**ADC Planning Consultation
Response from the Conservation Officer**

Application Number	AW/184/14
Address	The White House 24 Kingsway Aldwick PO21 4DH
Description	Retrospective application for the erection of a 6 panel, 1.5 m (h) x 1.5 m (w) fence at the north boundary of the property. This application affects the character and appearance of Craigweil House Conservation Area.
Case Officer	Mrs. J. Chapman

BLOCK PLAN
AREA 90m x 90m
SCALE 1:500 on A4
CENTRE COORDINATES: 490821, 98291

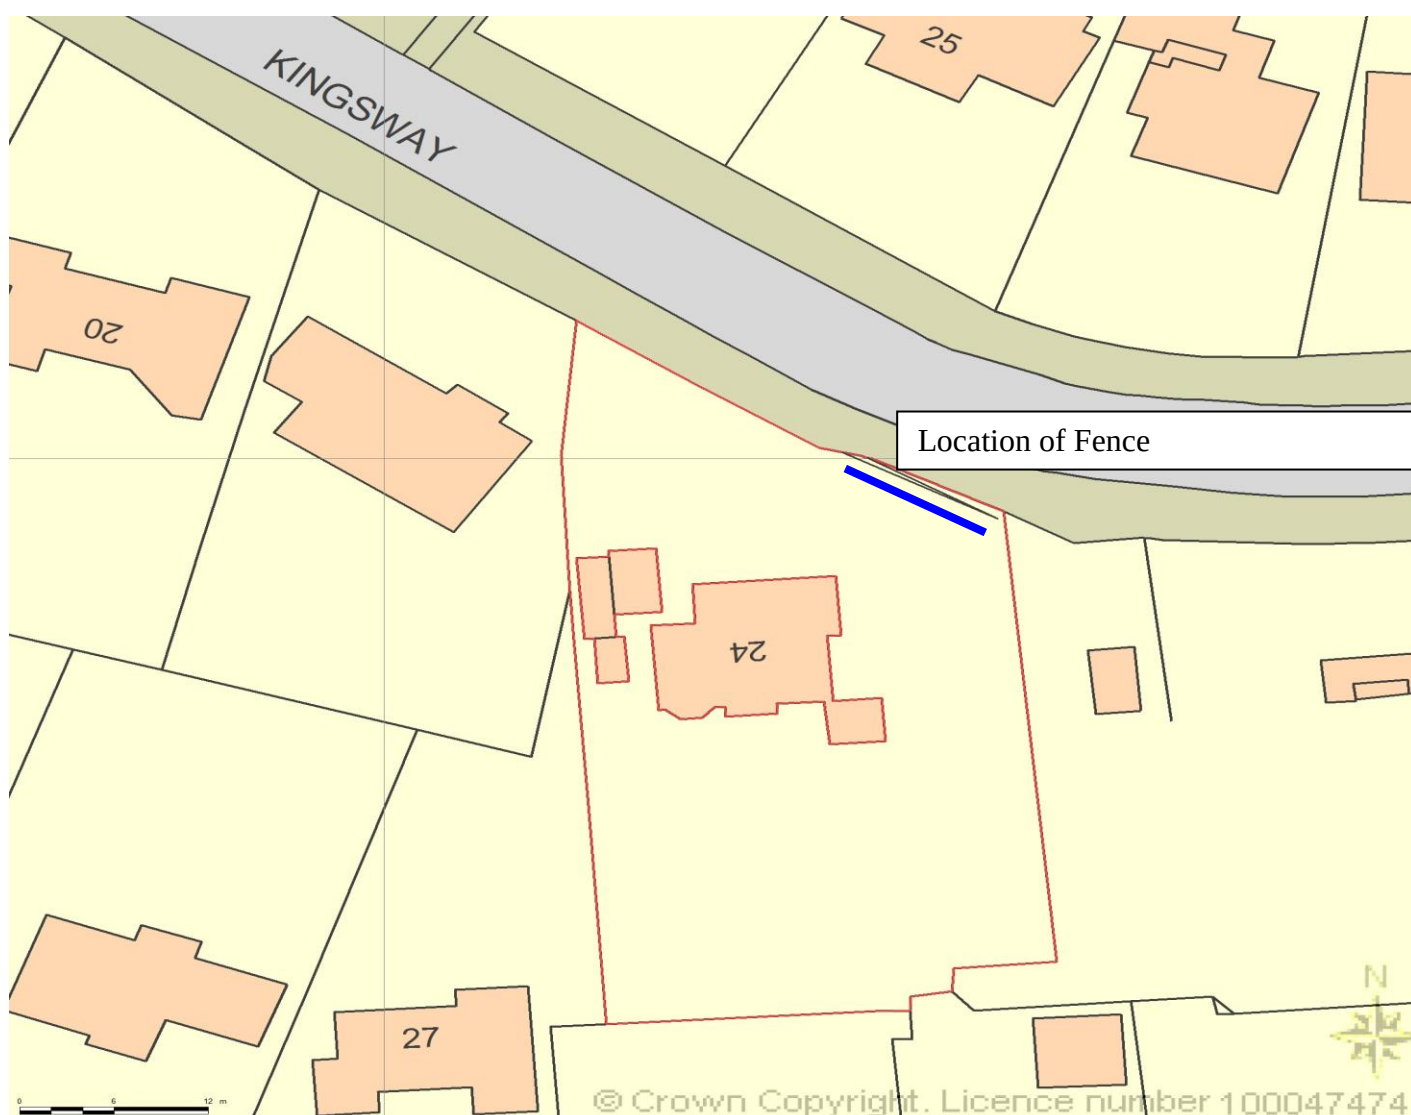
This is a retrospective application for replacement fencing along part of the front boundary. As such, the front boundary treatment consists of a mixture of close boarded fencing and a brick wall. There are two areas of concern; materials and the height of the fence.

It is considered that a mixture of materials along one individual property frontage creates a complex front boundary treatment. It is suggested that one material along the entire frontage is used.

Both materials are of different heights which jar/conflict with each other. The difference is not minimal and the height of the fencing conflicts with the established brick wall. It is considered that the boundary treatment should better reflect the height of the existing wall, rather than the neighbouring property.

These issues of height and materials are further exuberated when looking at the pedestrian gateway where the wall has a brick pier, whilst the fence has a wooden post.

It is suggested that a lower means of enclosure is introduced with some form of vegetation (large shrubs, hedging etc.) located behind it which can afford some privacy for the occupants (if this is required).
